**Re:** Prior Approval Application – Demolition of Bishop’s Court and Holme Park Court,  
Land South of Woodhead Lane and Parkgate, Berry Brow, Huddersfield, HD4 7HN

**Notice Date:** 28 November 2025

**Proposed Demolition Commencement Date:** 19 January 2026

Drawing
Existing Site Layout

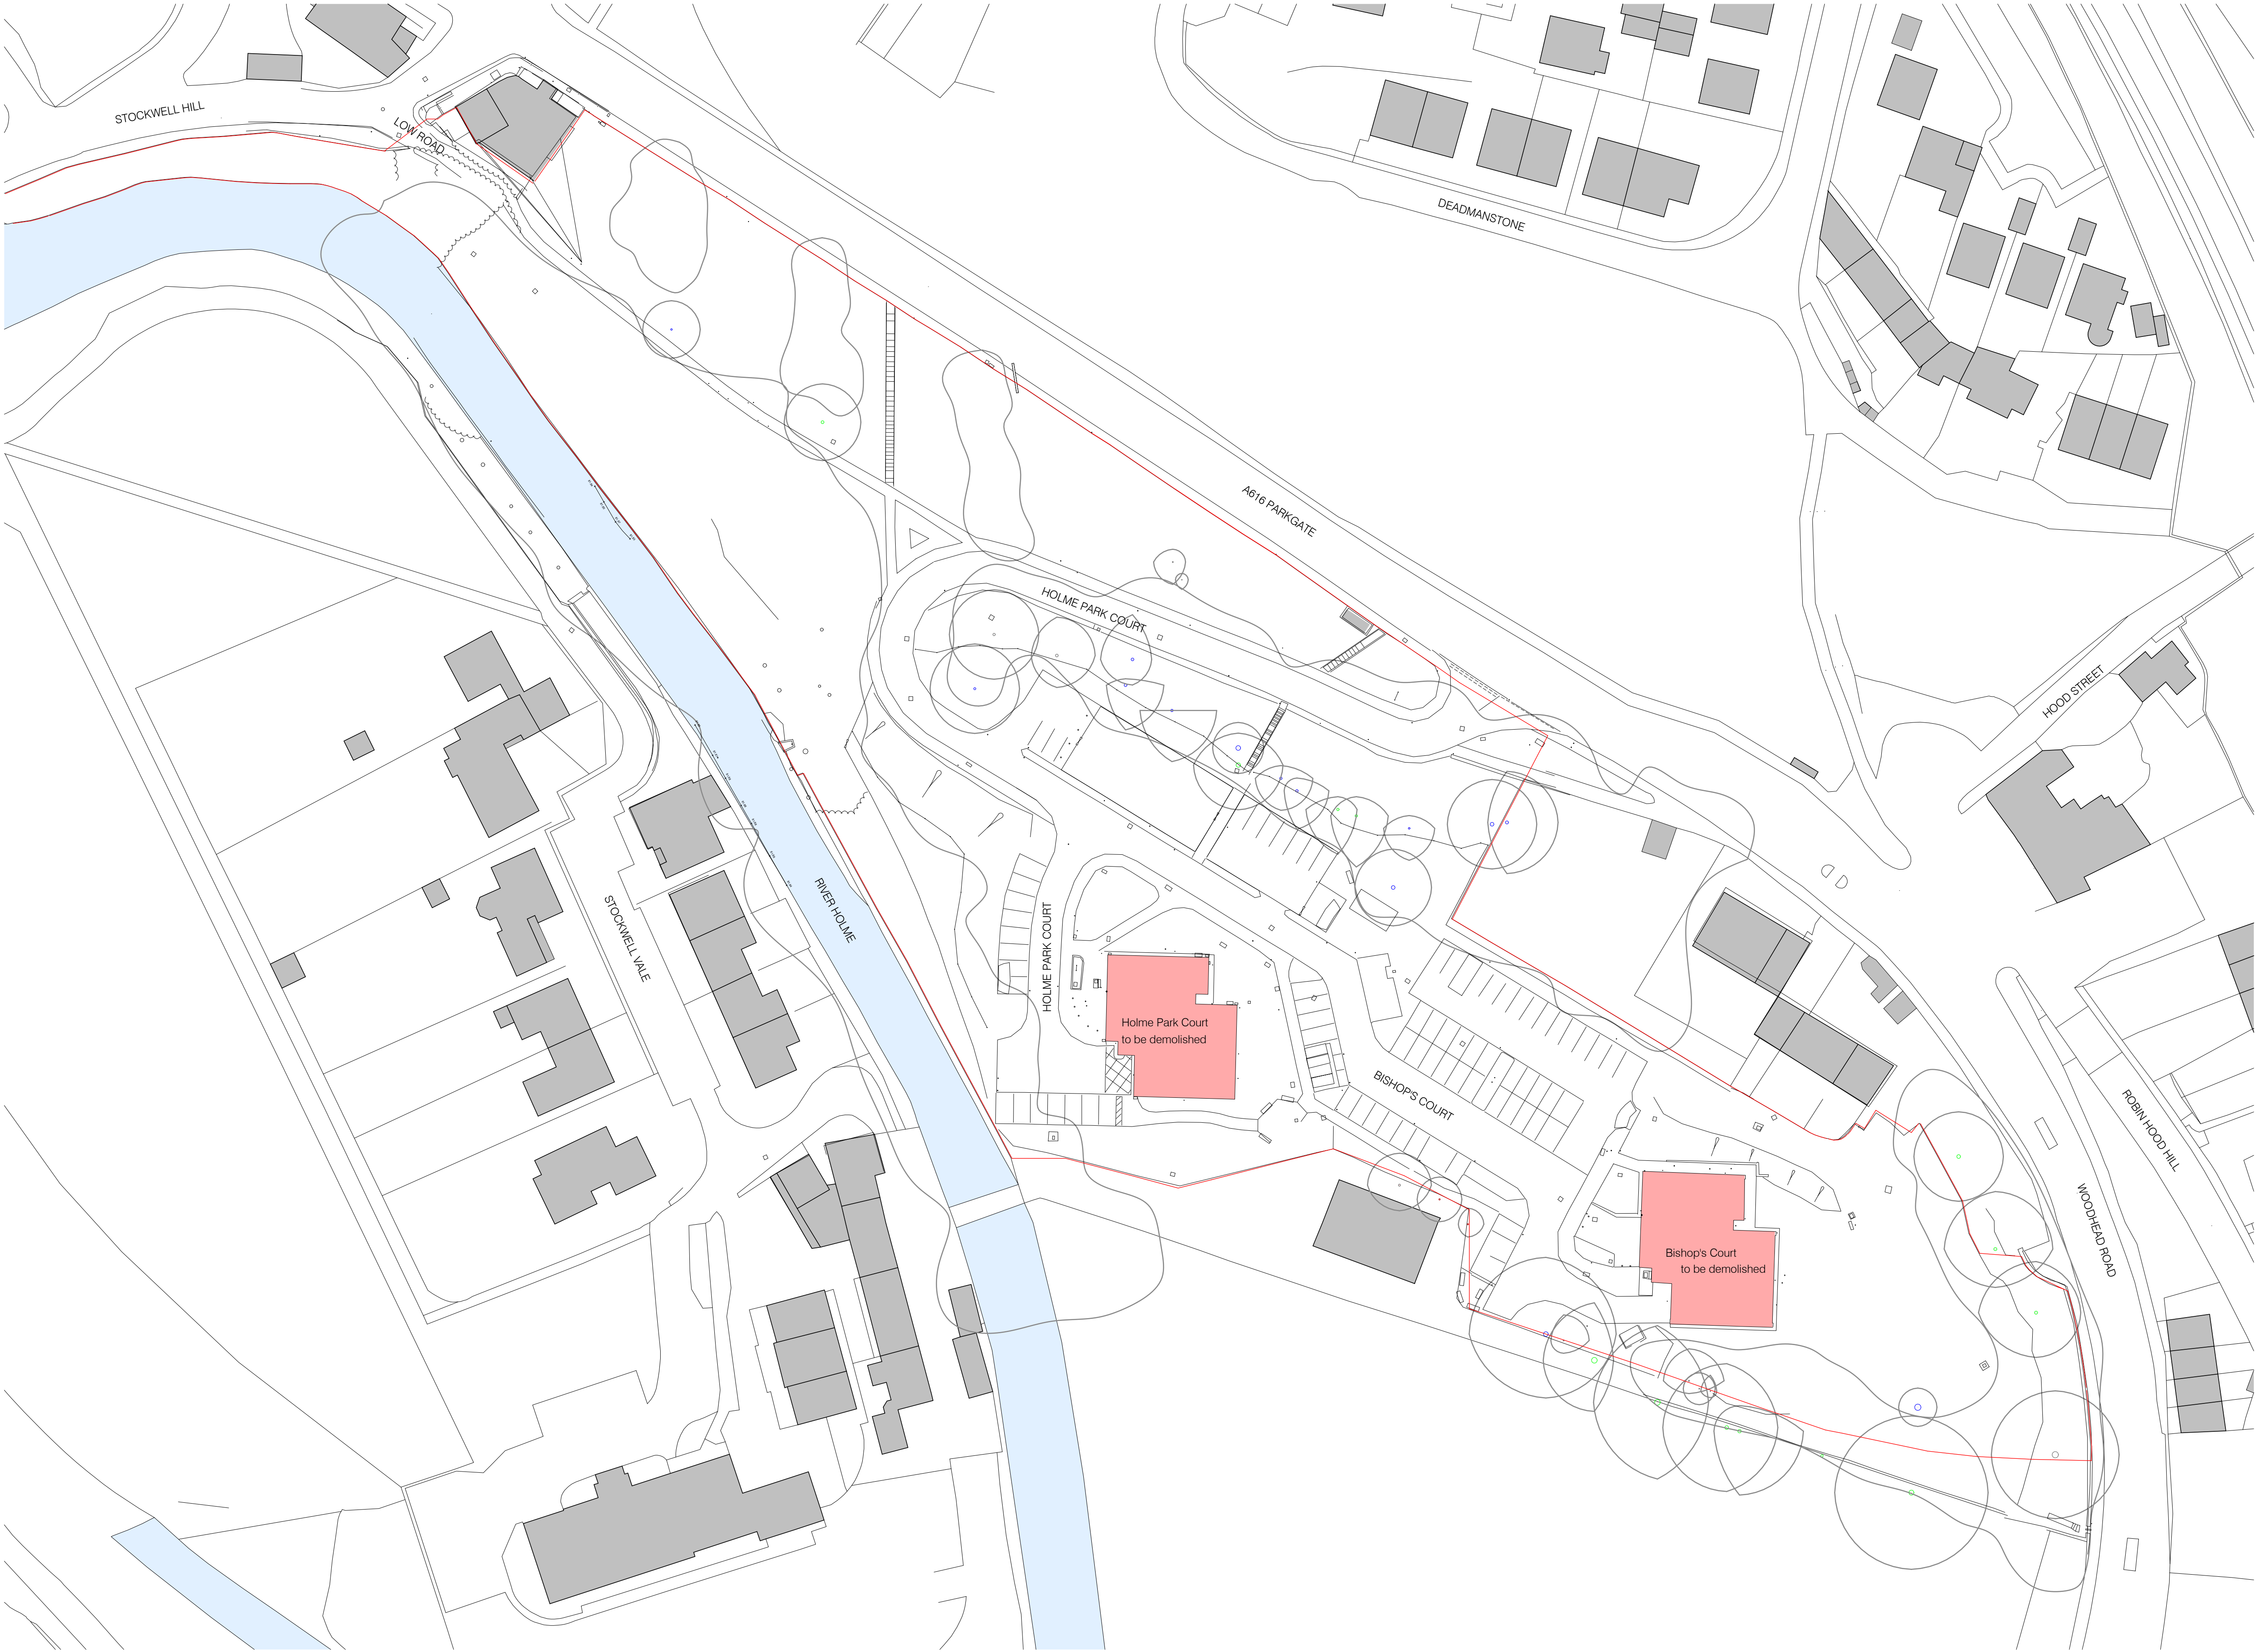
The site borders the River Holme, which has flooded recently, and the retaining wall is unstable. A Flood Risk Assessment and structural assessment must be completed, with mitigation measures approved by the Council and Environment Agency.

No pedestrian or vehicular access should be permitted both to and from Stockwell Vale. Appropriate physical barriers should be required and conditioned.
